WEST SUSSEX COUNTY COUNCIL CONSULTATION

TO:	Arun District Council FAO: Maria Tomalova
FROM:	WSCC - Highways Authority
DATE:	25 February 2021
LOCATION:	Pollards Nursery, Lake Lane, Barnham, PO22 0AD
SUBJECT:	Y/151/20/PL Permanent siting of temporary seasonal horticultural worker accommodation (8 mobile homes & 3 retrospective mobile homes), hardstanding & service building. This site also lies within the parish of Barnham, is in CIL Zone 3 (Zero Rated) as other development.
DATE OF SITE VISIT:	N/A
RECOMMENDATION:	Advice
S106 CONTRIBUTION TOTAL:	N/A

Scheme **Eric Wall Nursery, Lake Lane, Barnham, PO22 0AD**
Title **Proposed Site Plan (2 of 2)**

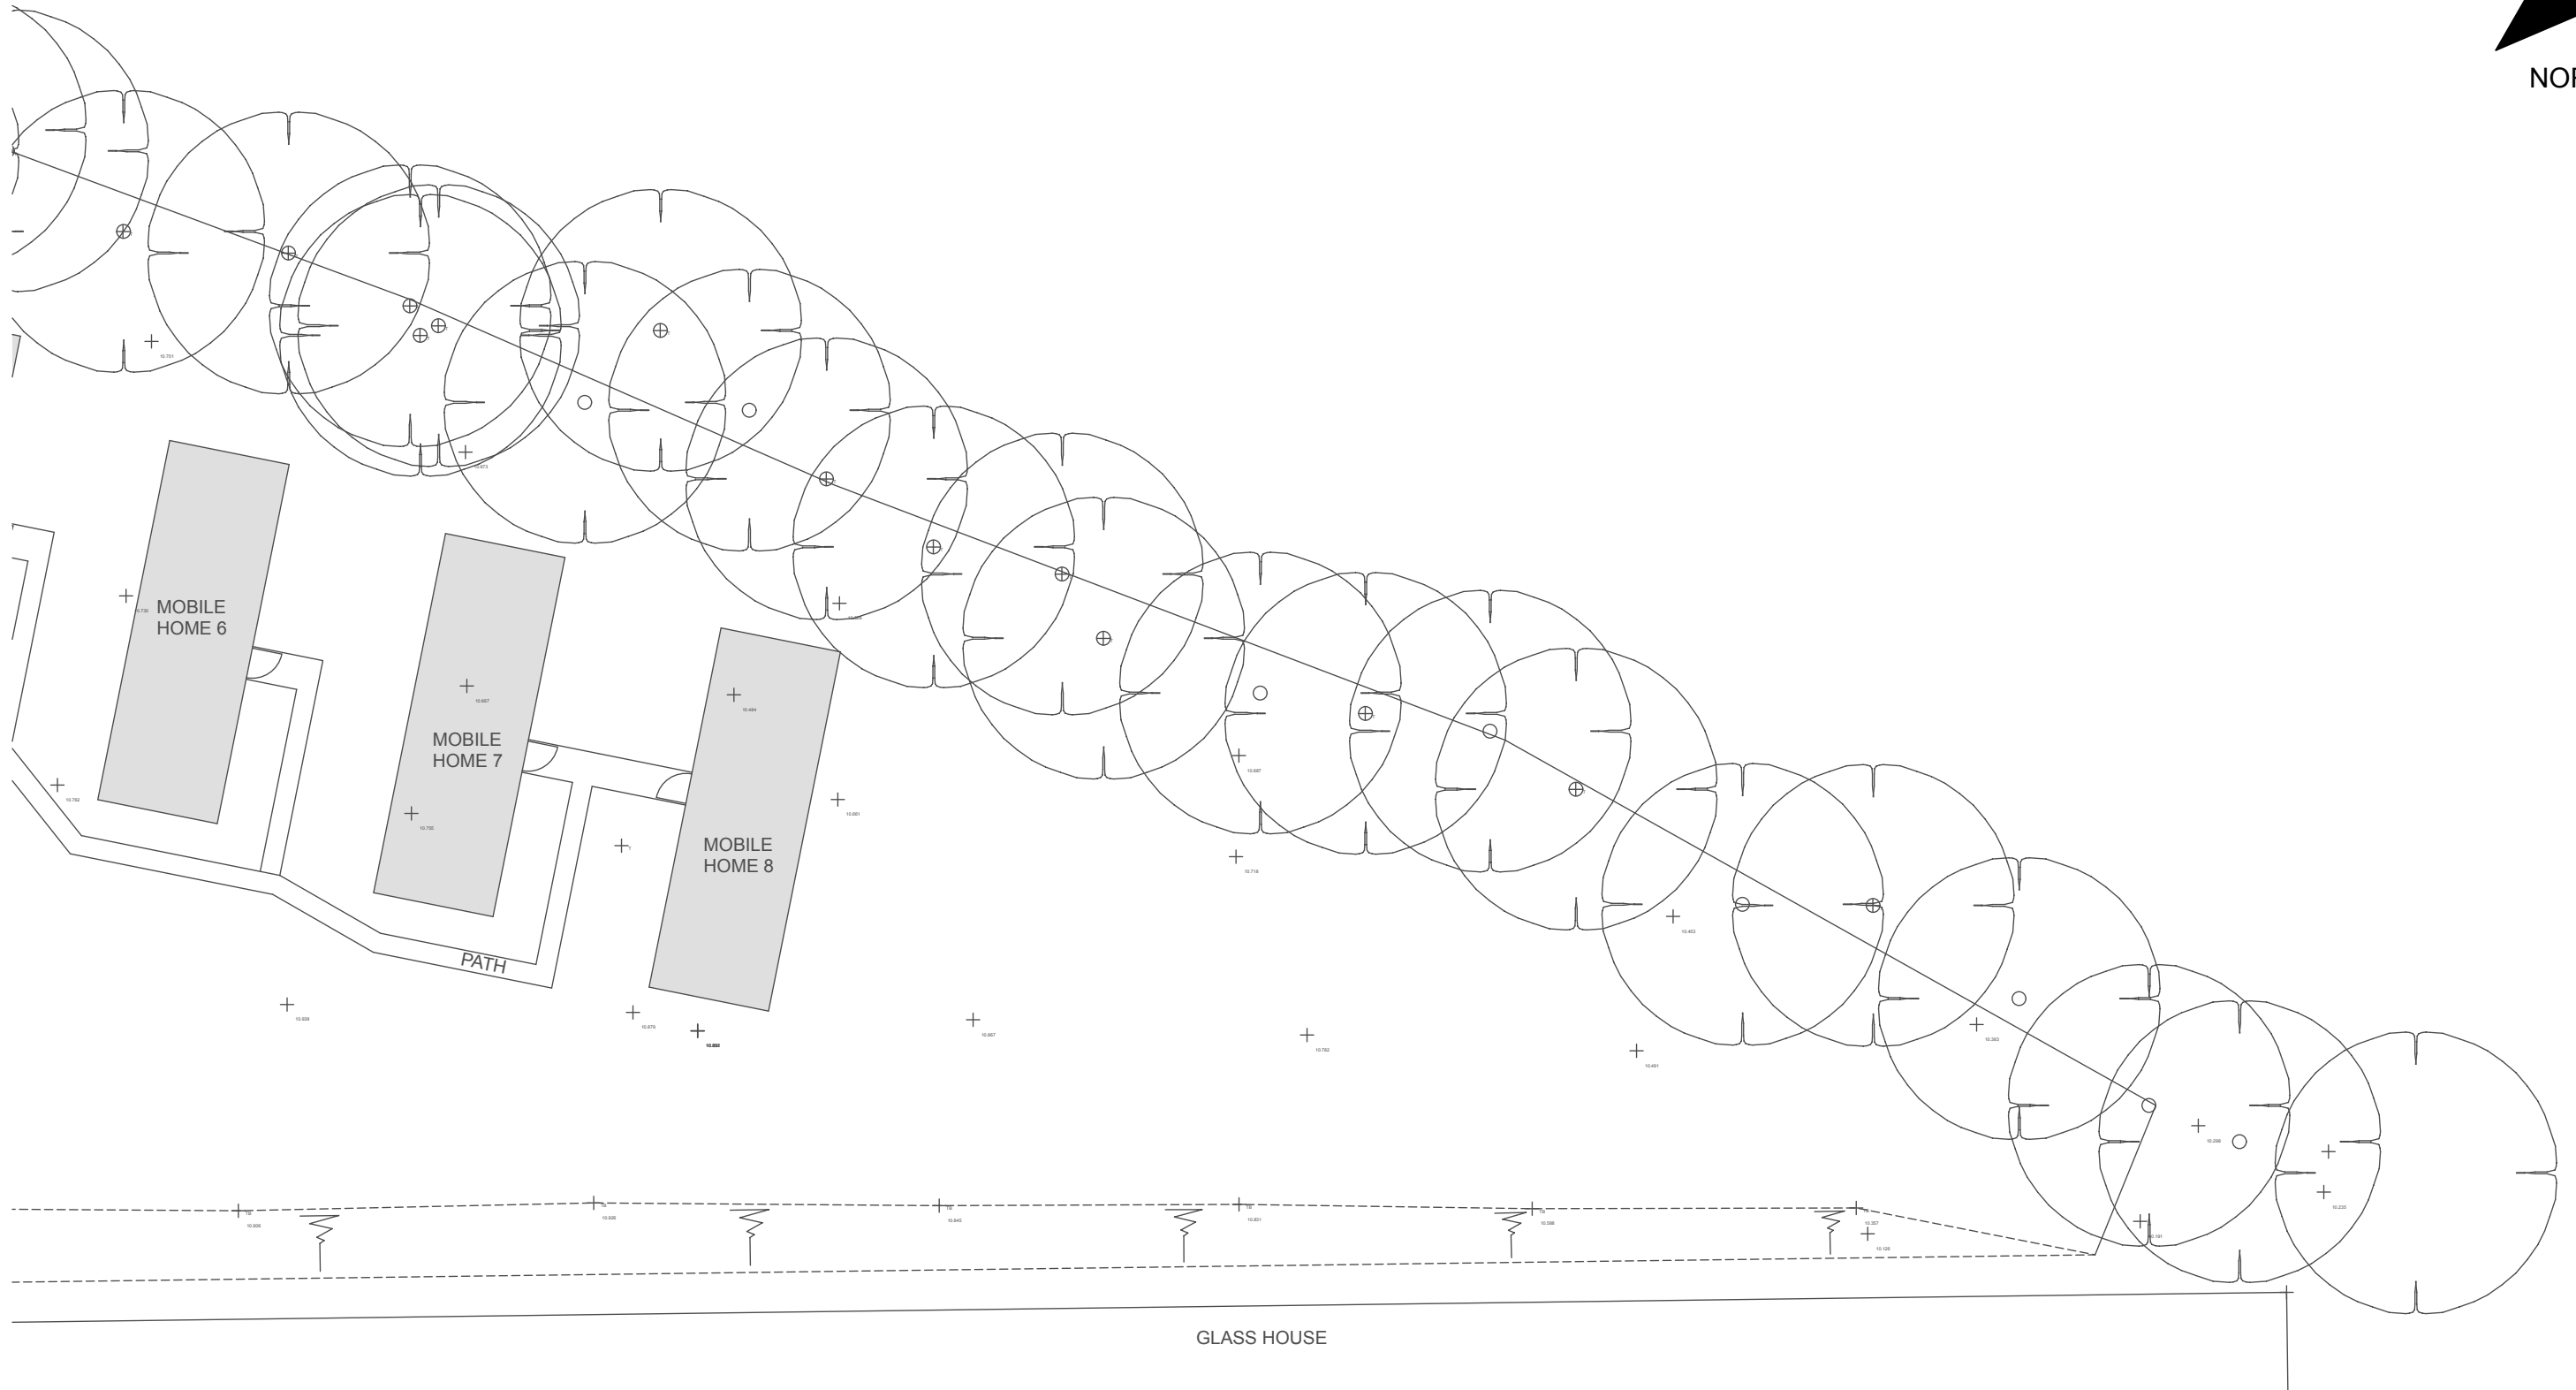
The applicant has not demonstrated vehicular parking provision for this development. The Design & Access Statement states that additional parking is not proposed, as car ownership amongst seasonal workers is anticipated to be low. Nevertheless, the LHA advises that the applicant should demonstrate the location of where cars will be accommodated on-site. From inspection of the plans, there appears to be adequate space on-site for sufficient parking to be accommodated.

The LHA advises the applicant to implement secure and covered cycle parking provision for use by residents, in accordance with WSCC parking standards. Cycling is a viable option in the area and opportunities for sustainable transport methods are within walking/cycle distance of the site.

Car parking space (details required)

No part of the development shall be first occupied until the car parking spaces have been constructed in accordance with plans and details to be submitted to and approved in writing by the Local Planning Authority. These spaces shall thereafter be retained at all times for their designated purpose.

Cycle parking

No part of the development shall be first occupied until covered and secure cycle parking spaces have been provided in accordance with plans and details to be submitted to and approved by the Local Planning Authority.
